Appeal Decision

Appeal Ref: APP/R5510/D/22/3312541

5E Frays Way, Uxbridge, UB8 2RJ

- The appeal is made under section 78 of the Town and Country Planning Act 1990 against a refusal to grant planning permission.
- The appeal is made by Miss R Kaur Sarao against the decision of the Council of the London Borough of Hillingdon.
- The application Ref 77453/APP/2022/2448, dated 1 August 2022, was refused by notice dated 5 October 2022.
- The development proposed is a single storey side extension.

FILE/REF/REFERENCE	1575	REV.	DATE	DESCRIPTION	INITIAL
CLIENT	MISS RAJPAL KAUR SARAO				
SITE/PROJECT	PROPOSED EXTENSION AT 5E FRAY'S WAYE UXBRIDGE				
PLANS AND ELEVATIONS AS PROPOSED					
DRAWING NO.	1575-02	DRAWN BY	ED CLARE	CHECKED BY	
DATE	JUL-2022	PAPER SIZE/SCALE	A2 1:100	REVISION

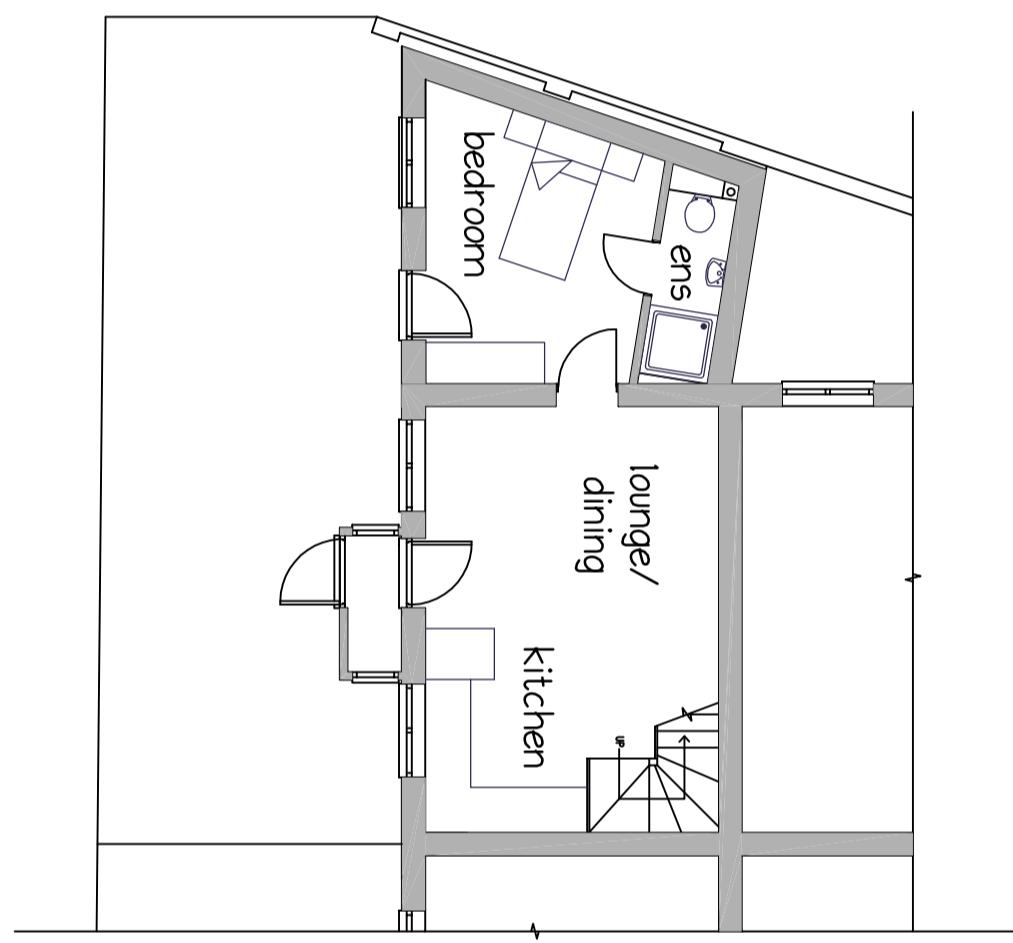
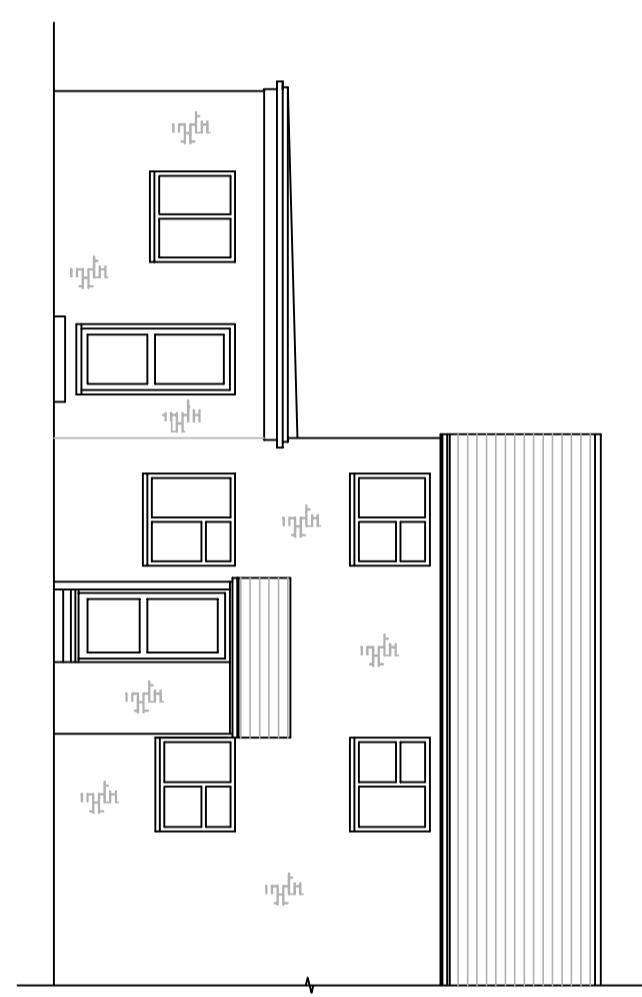
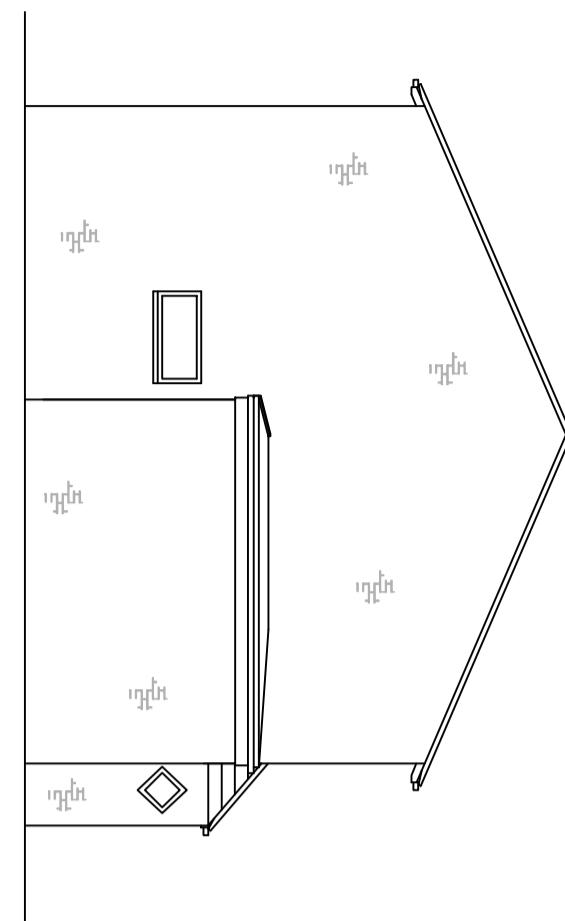
9. The development would be comprised of a flat roof extension, with its front wall taking over the spot currently occupied by a plain timber fence, albeit that the extension would be a little higher than the fence. When approached from both the west and east, views of the extension would be largely masked by extant development, including the brick wall and palisade fencing fronting the school's car park; one of the school's outbuildings, and neighbouring dwellings in Frays Way. It would be most exposed in views from the south for a short distance when approaching along Waterloo Road. But because of its small scale, and that it would replace an extant timber fence, the extension's presence, notwithstanding the door and window in the front elevation, would not prove particularly noticeable.

10. In this respect, the Council acknowledges that the extension's height '*would be appropriate to the host dwelling*' but consider its width to be excessive at more than half the width of the dwelling to which it would be attached. However, in my view, the Council have given insufficient weight to the presence of the fence and its visual impact, and to the fact that the appeal dwelling forms part of a small terrace. I consider the extension to be entirely proportionate in scale in its terraced context.

11. I therefore conclude that whilst the proposal may not strictly comply with all of policy DMHD 1's criteria, the proposal would not result in harm to the character and appearance of the host property or its surroundings. Accordingly, the
